From: Rebecca Payne on behalf of Planning Scanning
Sent: 19 August 2020 10:59
To: Planning Scanning
Subject: FW: FW: 22995 - Manor Nursery A/86/20/DOC - Designer Response

Please upload onto Ocella the email trail below which is a further consultation response from **ADC Drainage Engineers** to discharge of condition application **A/86/20/DOC** regarding Manor Nursery, High Street, Angmering.

Condition 21- surface water drainage design

- NETWORK 1 (TOTAL=1,575m²)
- NETWORK 2 (TOTAL=843m²)
- NETWORK 3 (TOTAL=394m²)
- NETWORK 4 (TOTAL=273m²)
- NETWORK 5 (TOTAL=272m²)
- NETWORK 6 (TOTAL=205m²)
- NETWORK 7 (TOTAL=599m²)
- NETWORK 8 (TOTAL=595m²)
- NETWORK 9 (TOTAL=280m²)
- NETWORK OTHER (TOTAL=740m²)

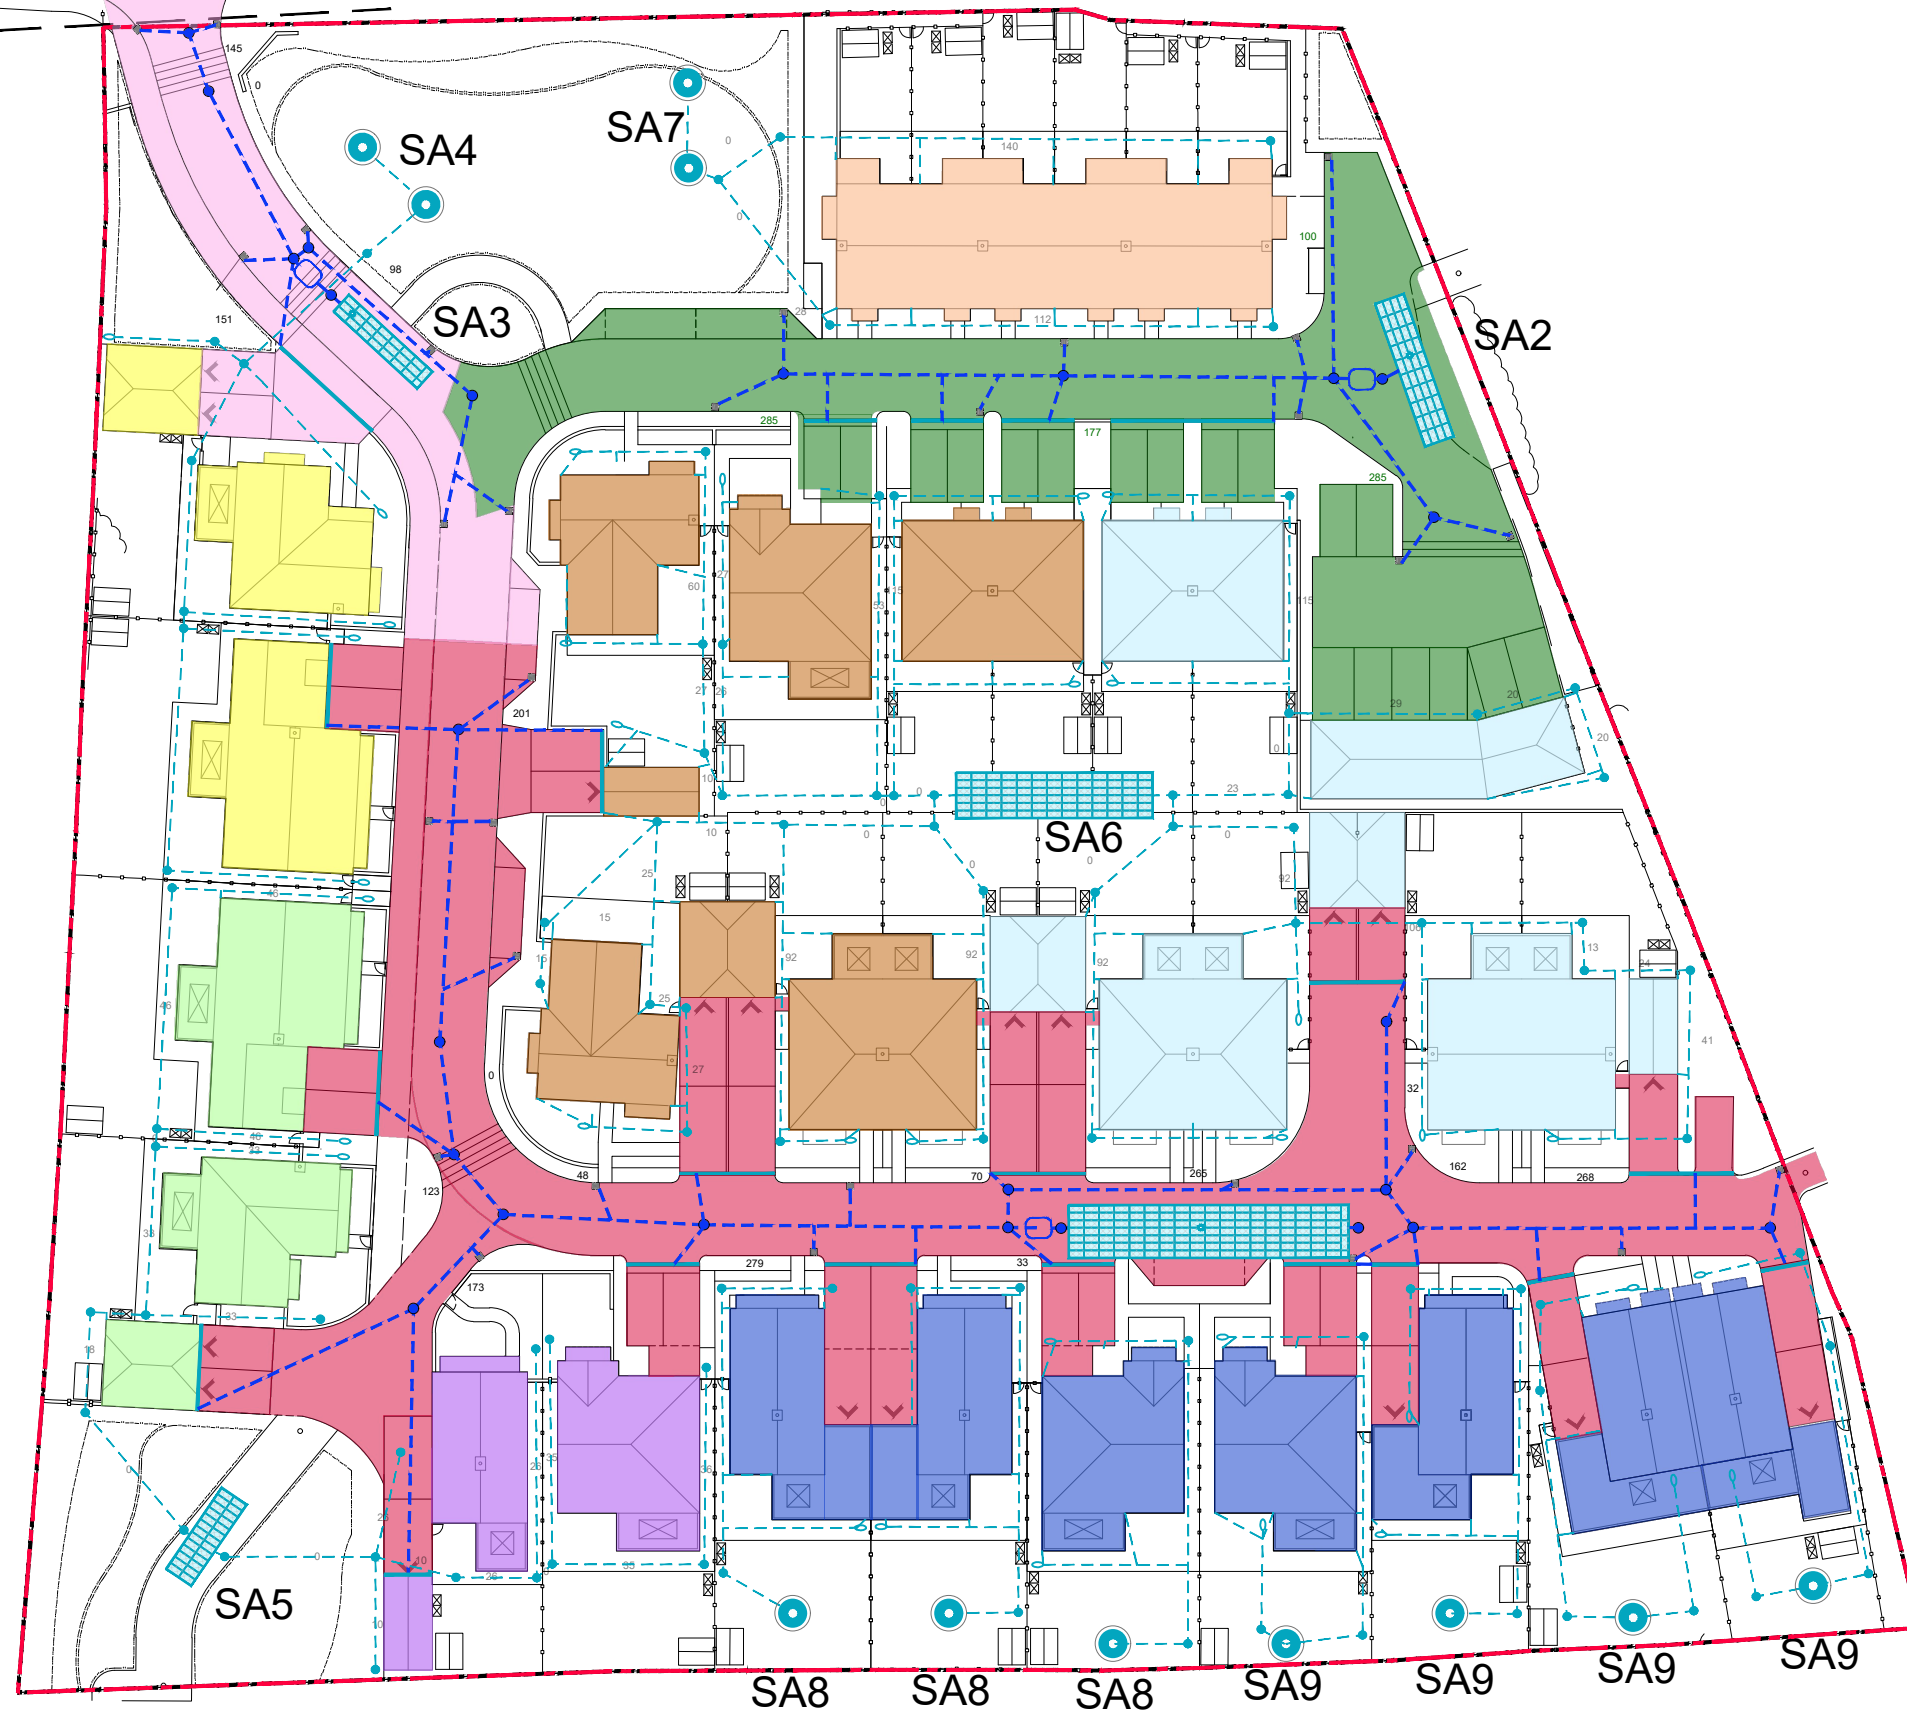
3. All infiltration tests were undertaken at circa 2.5m depth, yet some of the soakaways are considerably shallower than this.

We will require further information on how adequate treatment of surface water is occurring prior to discharge to ground in accordance with chapter 26 of CIRIA C753. There is no evidence of any pollution mitigation prior to discharge to soakaways. This is a particular concern regarding water from highways where pollution hazard indices are higher.

The design notes only two soakaway designs with the base shallower than 2.5m blg. These are SA8 and SA9 and both are located within the gardens of the properties along the southern boundary of the site. Soakage testing was undertaken at a depth of 2.5m within the gravel strata below the site. The trial pit logs within this area, TP1, TP2 and TP3, confirm the gravel strata is located at between 2.1 and 2.2m below ground and extends to the base of the trial pits. SA8 and SA9 soakaways are situated within this gravel strata. We therefore request this objection is removed based on the designed soakaways' depth extending into the tested soil strata where they will have the same performance as the tests. We have attached the Trial Pit data and location plan. Acknowledged that the same strata does just about extend to base, however ring soakaways are proposed which rely upon sides for infiltration only therefore they will not be utilising this gravel strata. We would recommend that these soakaways are made deeper to extend further into the gravel strata, but the base must be kept above peak groundwater levels/ base of monitoring wells.
